Application by Mona Offshore Wind Limited for Mona Offshore Wind Farm

Response by Stena Line UK Limited (Stena Line) - (Ref: 200476870) -

To the ExA's written questions and request for information (ExQ2) - Deadline 5

Q2.15.2 - Residual effects on Stena Line operations

Analysis of the deviations required by the cumulative effect of the proposed development of the Morgan, Mona, Morecambe and Orsted Windfarms on Stena Lines Belfast to Liverpool services.

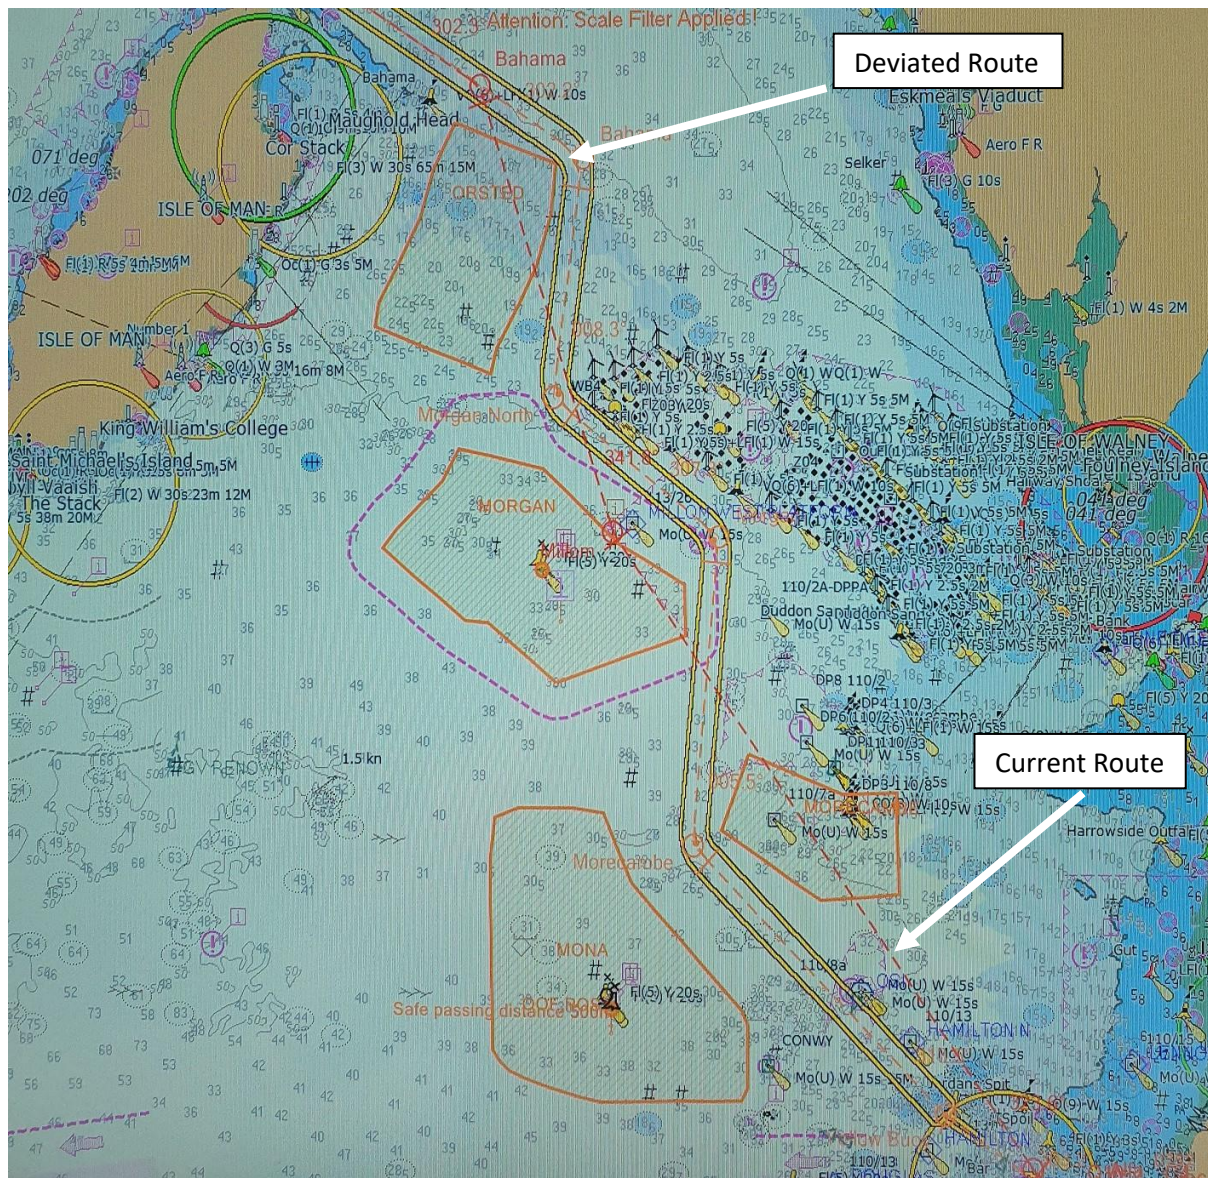
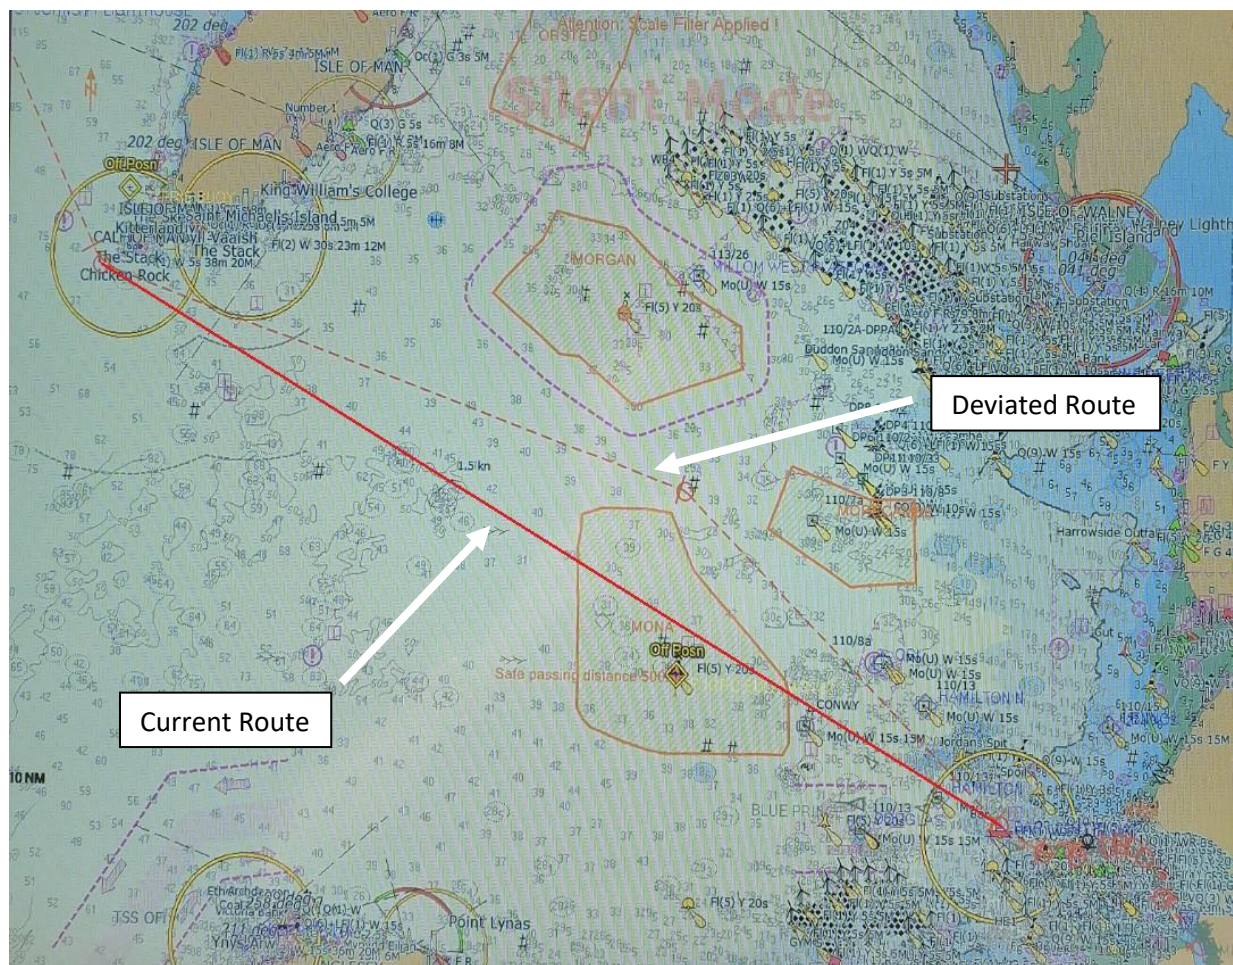
The individual and cumulative development of the four offshore wind farms would effectively obstruct the currently direct line of passage between the ports. Fig 1 shows the magnitude of the physical deviation which is 5.5 Nm passing North of the Isle of Man and c 1.5 Nm passing South of the Isle of Man.

As a consequence, whilst it is certainly the case that the Stena Line vessels would have the option of diverting from their currently direct line of passage and could as an alternative transit either to the north or south of the Isle of Man, such a forced diversion would create serious commercial implications in terms of service challenges , operational practicality and navigational safety.
